<b>Consultation Response from: KC Environmental Health (Pollution &amp; Noise Control)</b>		
<b>2026/91459 Jack's Barn, 22, Stringer House Lane, Emley Moor, Huddersfield, HD8 9SU</b>		
<b>Erection of detached building to create dwelling forming annex accommodation associated with Jack's Barn, 22, Stringer House Lane, Emley Moor, Huddersfield, HD8 9SU with garage and decking</b>		
<b>Date Responded:</b> <b>03/07/2025</b>	<b>Responding Officer:</b> <b>CH</b>	<b>Responding Ref:</b> <b>WK/202619248</b>
<p>We have reviewed the application and supporting information and make the following comments and recommendations. Please note that these comments are based on the information available to us at the time of writing but may be subject to change for any future planning application.</p> <p><b>Foul Drainage</b></p> <p>The development proposes to dispose of foul sewage via a septic tank and includes proposals to connect to the existing drainage system. However, the information submitted is insufficient. Our records show that a mains sewer is approximately 25 m from the site, we would expect connection to the main sewer to be considered as first option.</p> <p>It is unclear whether the septic

SITE PLAN
1 : 200

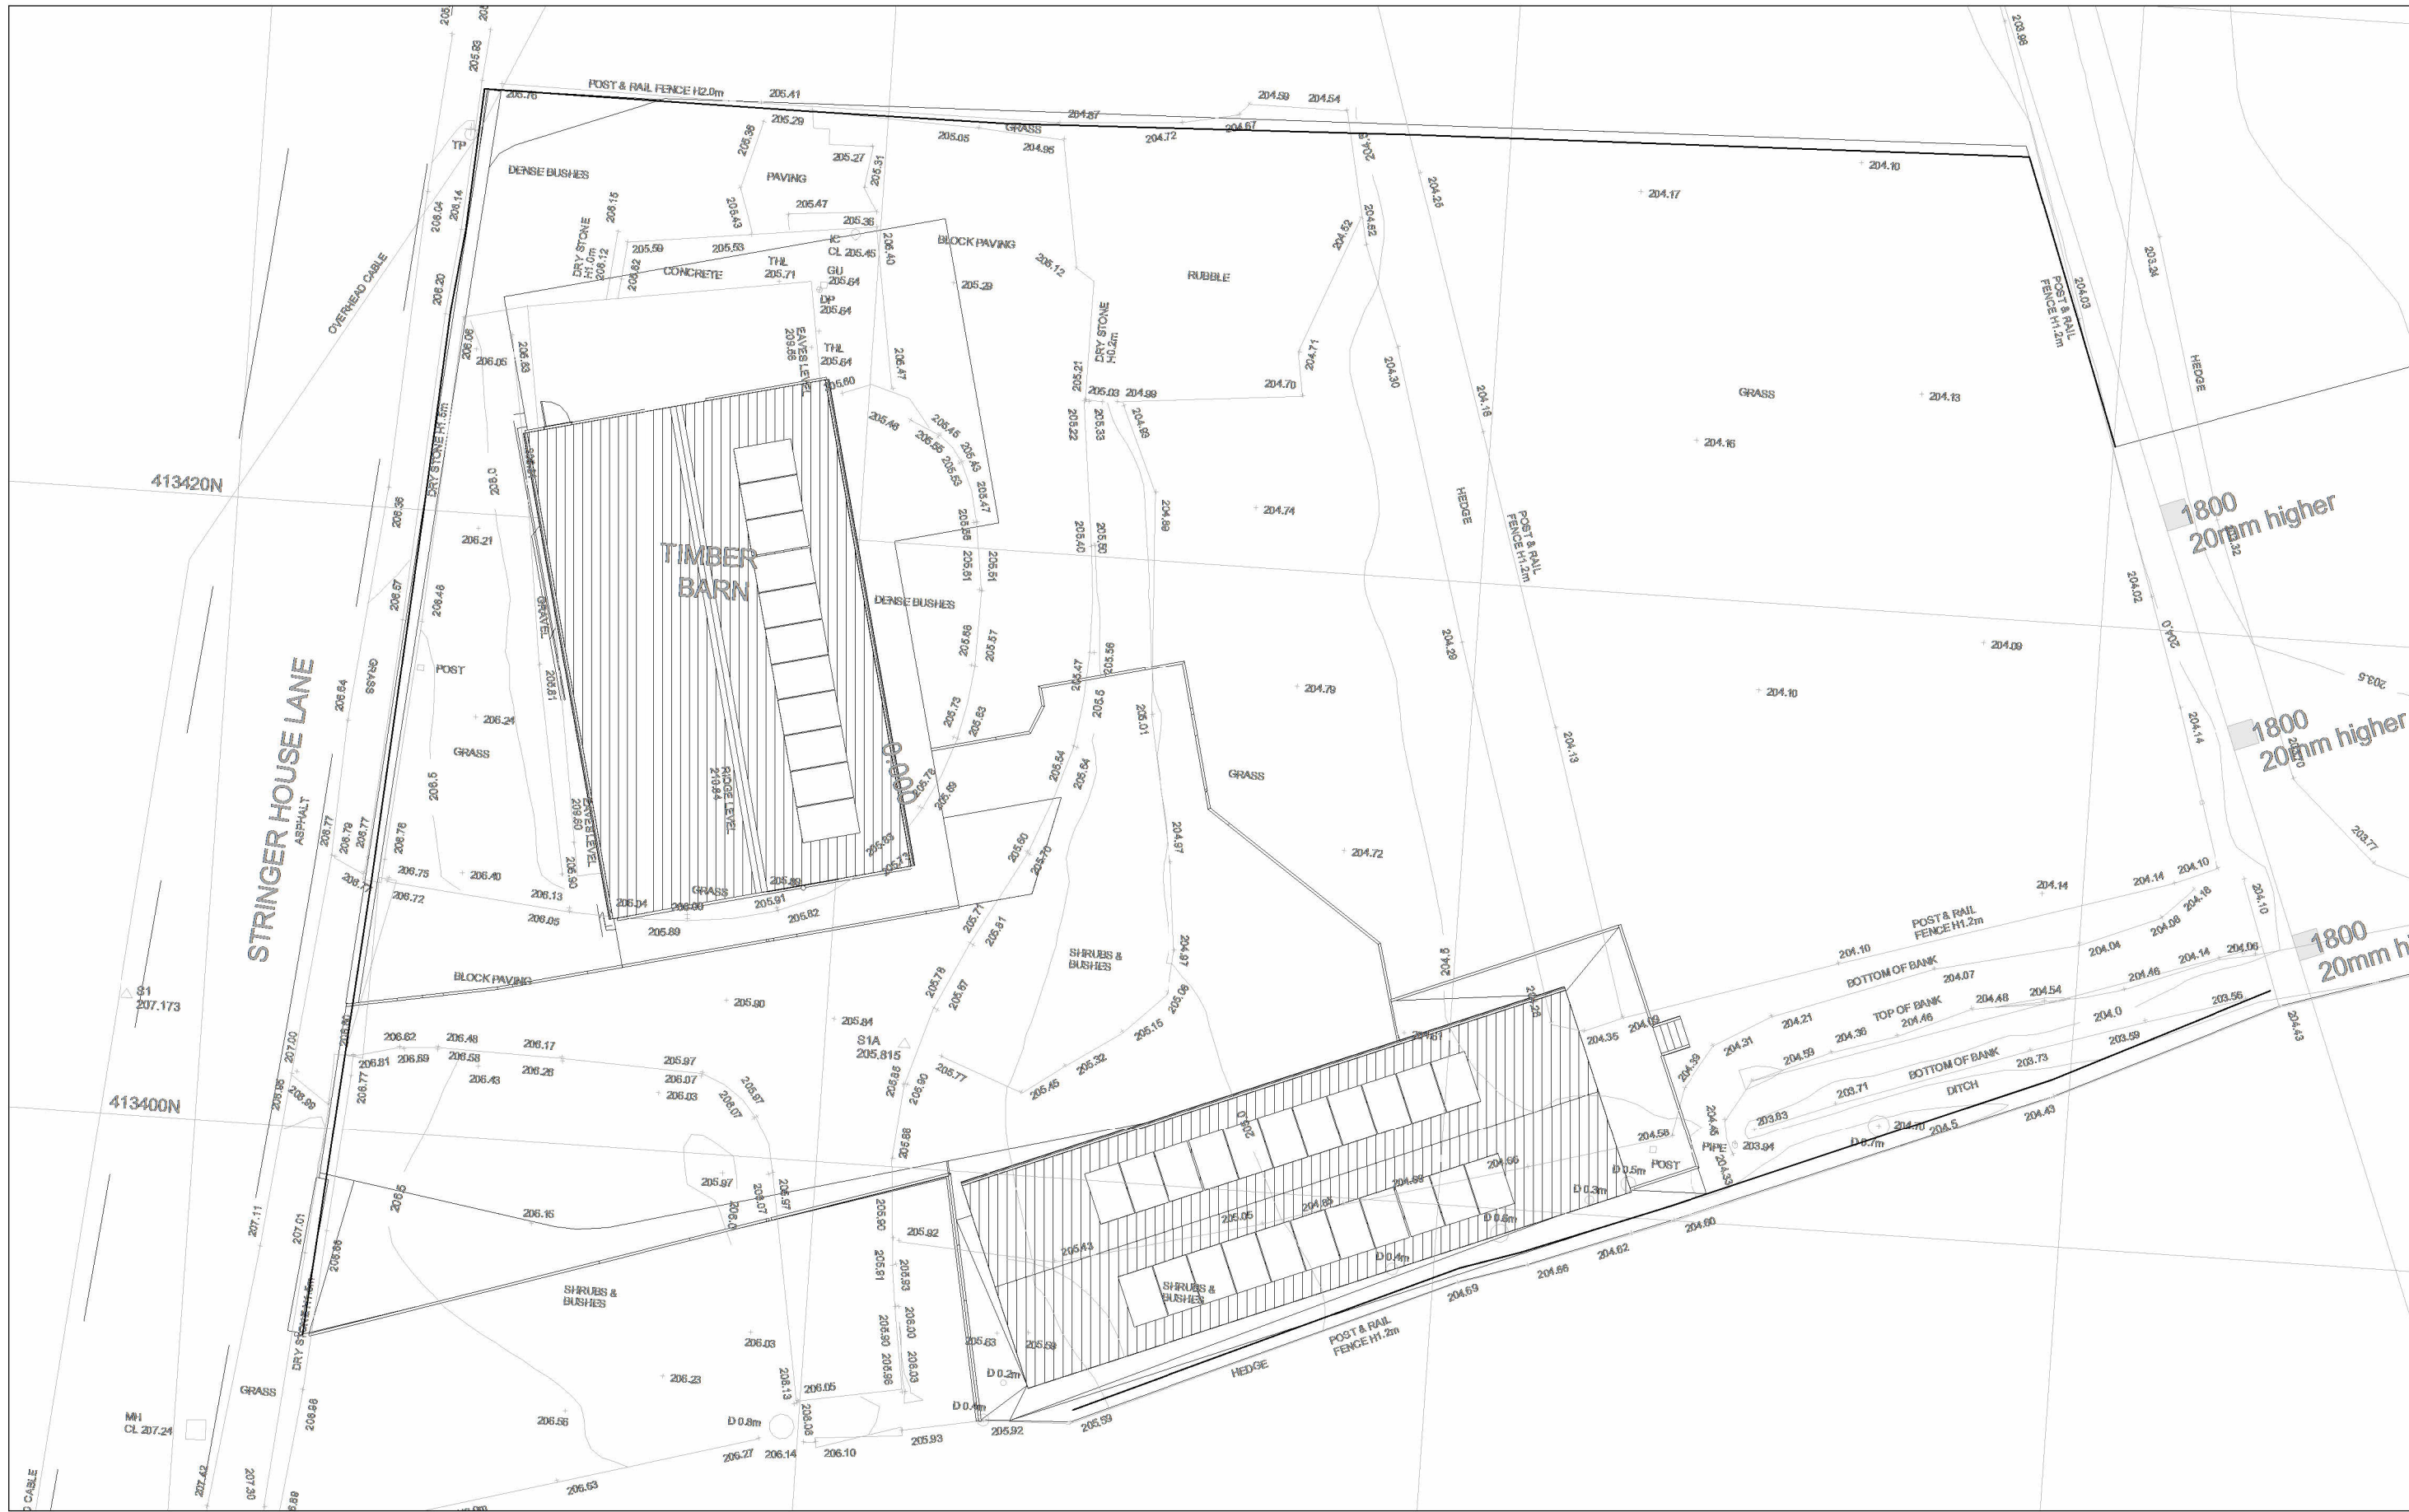
We require information in relation to foul drainage for this development. Whilst the application indicates that foul sewage would be disposed of via a septic tank and that a connection to an existing drainage system is proposed, no supporting details have been provided. In particular, the application fails to clarify whether the septic tank is existing or proposed, and no information has been submitted in respect of the existing drainage system or any connection to it.

Prior to determination, the applicant must submit full details of the foul water drainage arrangements. This shall include confirmation of whether a mains sewer connection is available and feasible, or if a non-mains solution is to be used, details of the septic tank including its location (supported by a plan), design, capacity, and the population it will serve. The applicant must also provide details of the existing drainage system, how the proposed development will connect to it, and the method of discharge. This information is required to ensure that an appropriate and compliant system can be achieved and to prevent potential pollution of the environment, in accordance with Policies LP34 and LP52 of the Kirklees Local Plan and Chapter 15 of the National Planning Policy Framework
